RE WORTLEY VILLAGE PLAN

Following our site meeting at Wortley Village on 20th October 2016. Please find attached the following drawings revised as per our onsite discussions.

JOB NO. 08-03 REV P1
DRAWING NUMBER

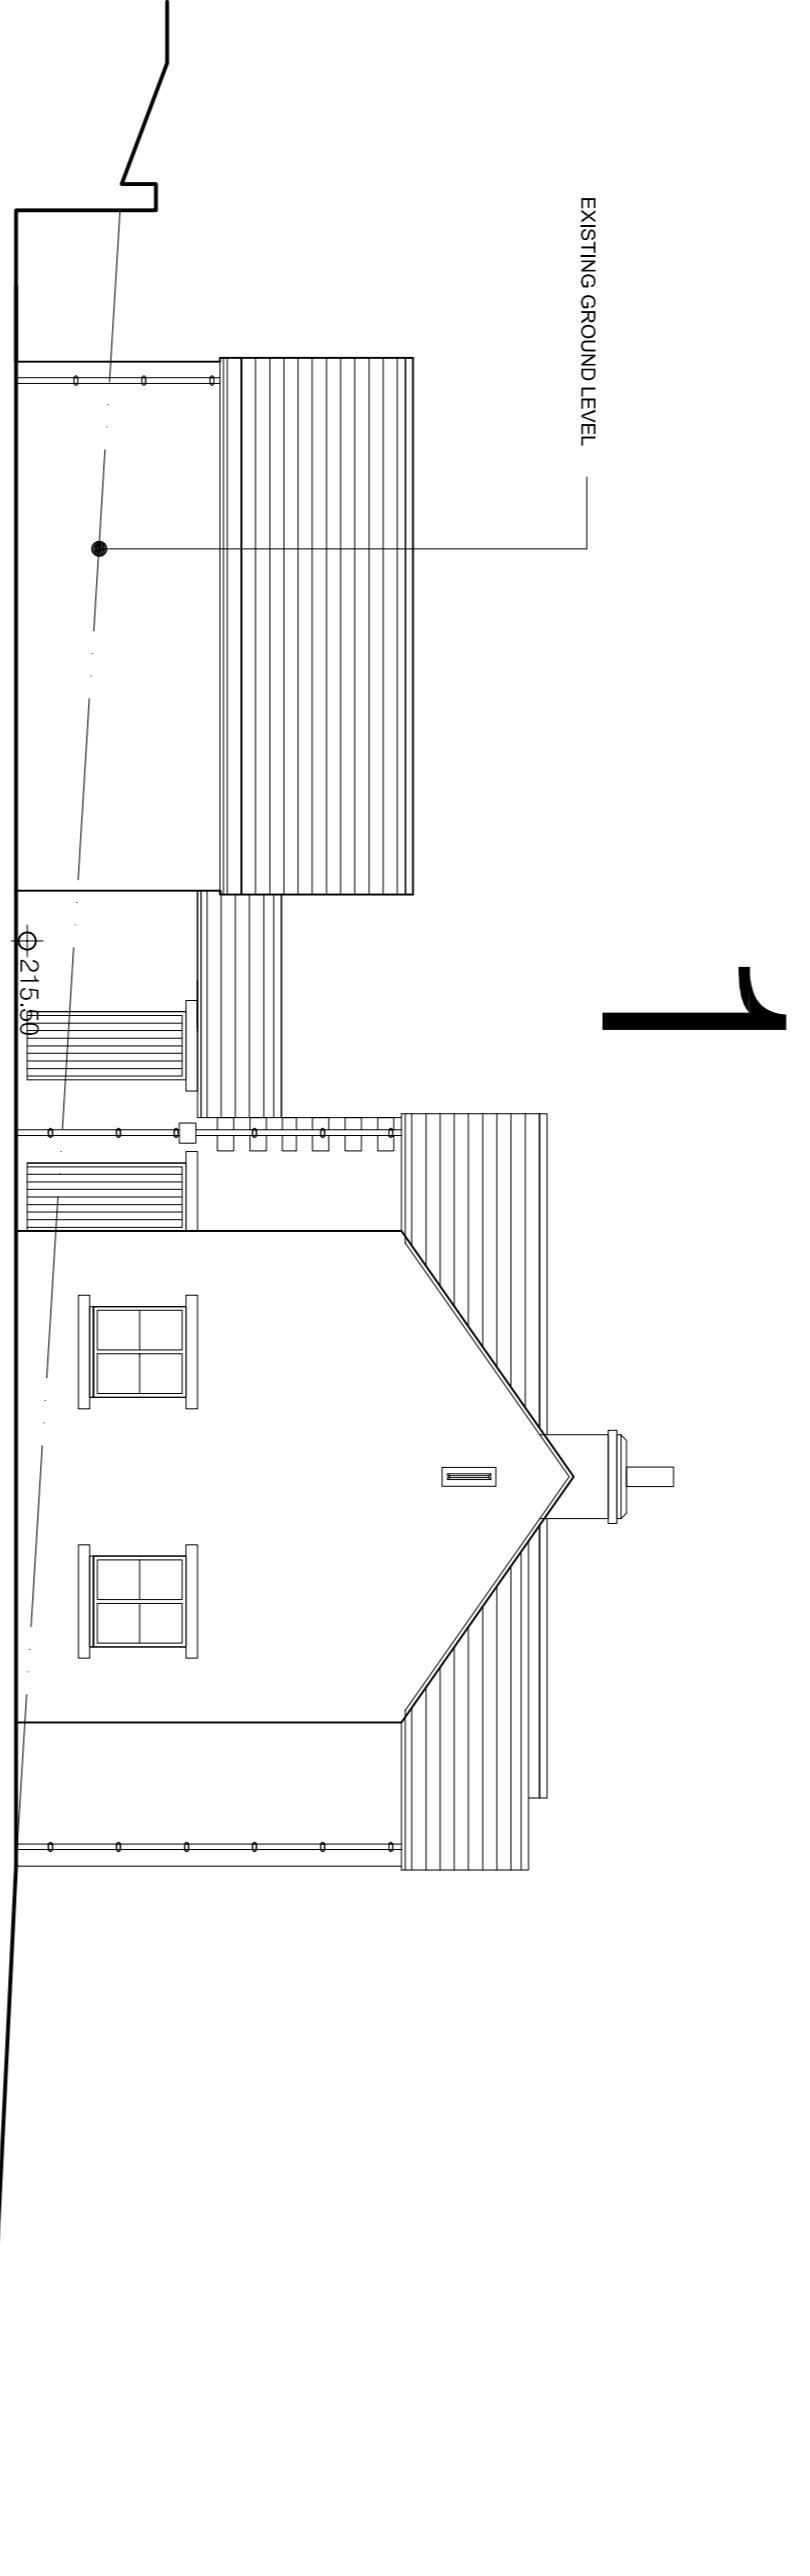
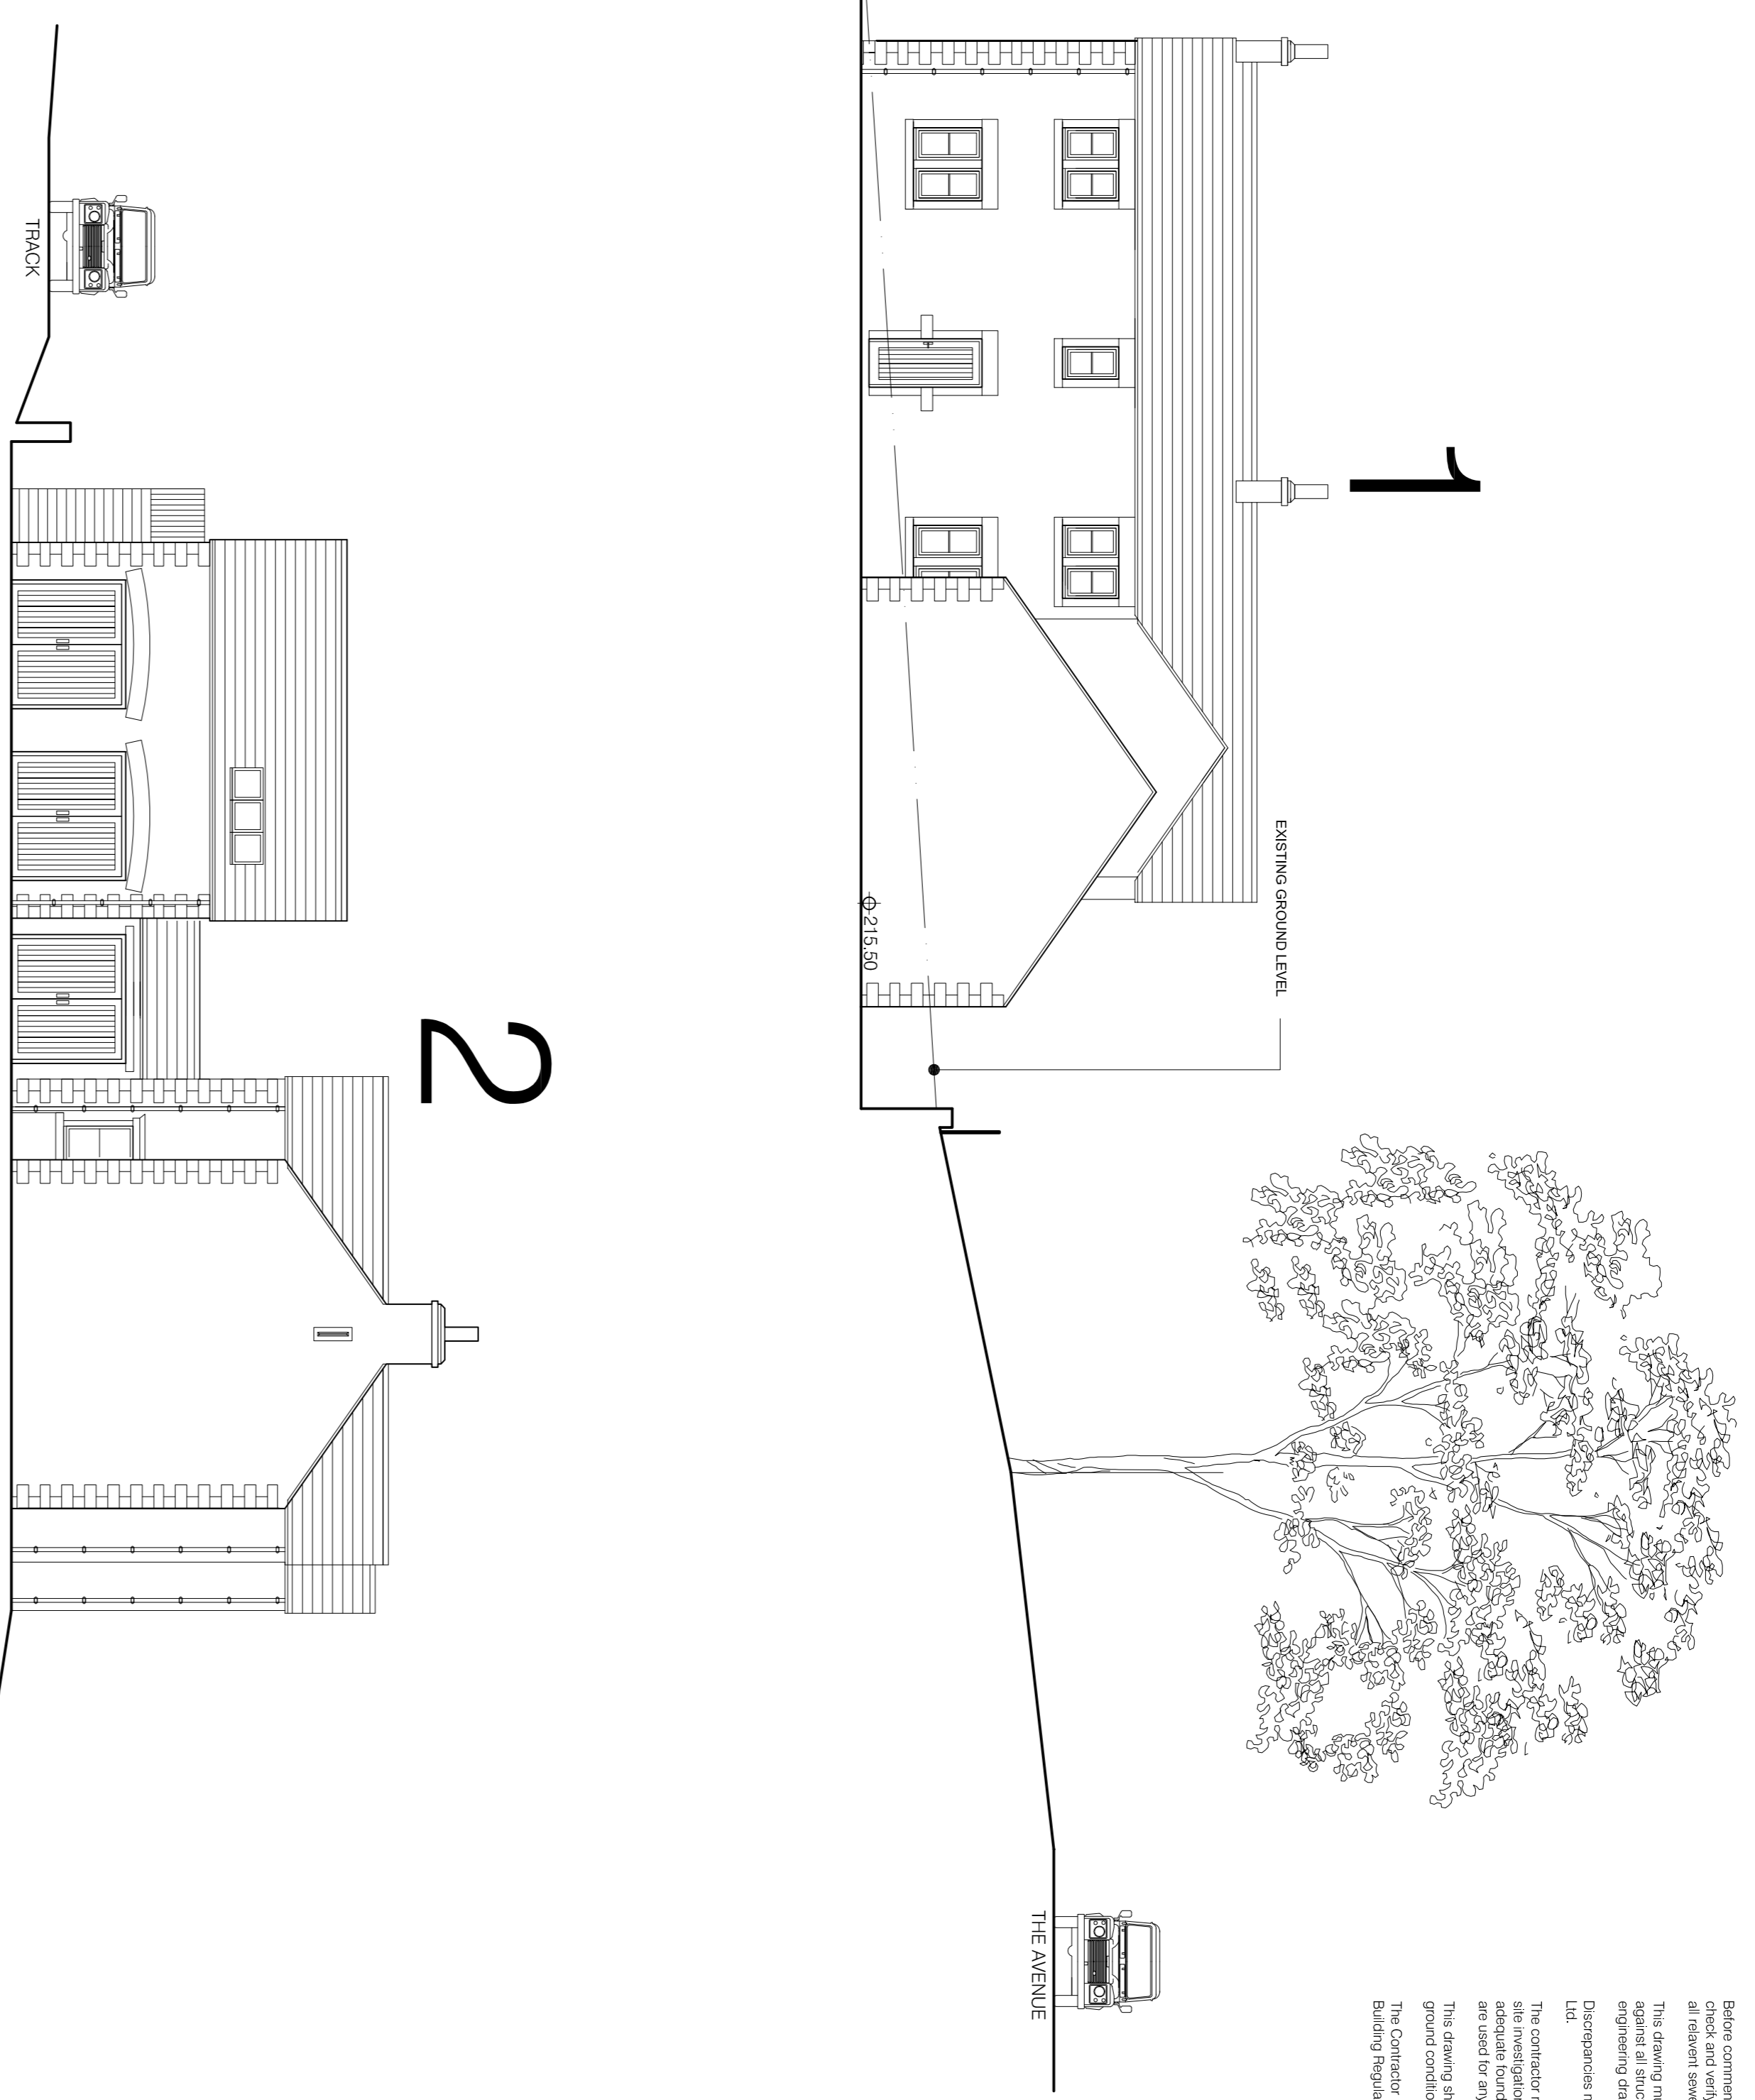
- 707-08-02-P1** Plans and elevations amended to reduce proximity to neighbours and provide difference in appearance of plots 1 & 2
- 707-08-03-P1** Elevations & sections amended to show alternative approach to elevations of plots 1&2
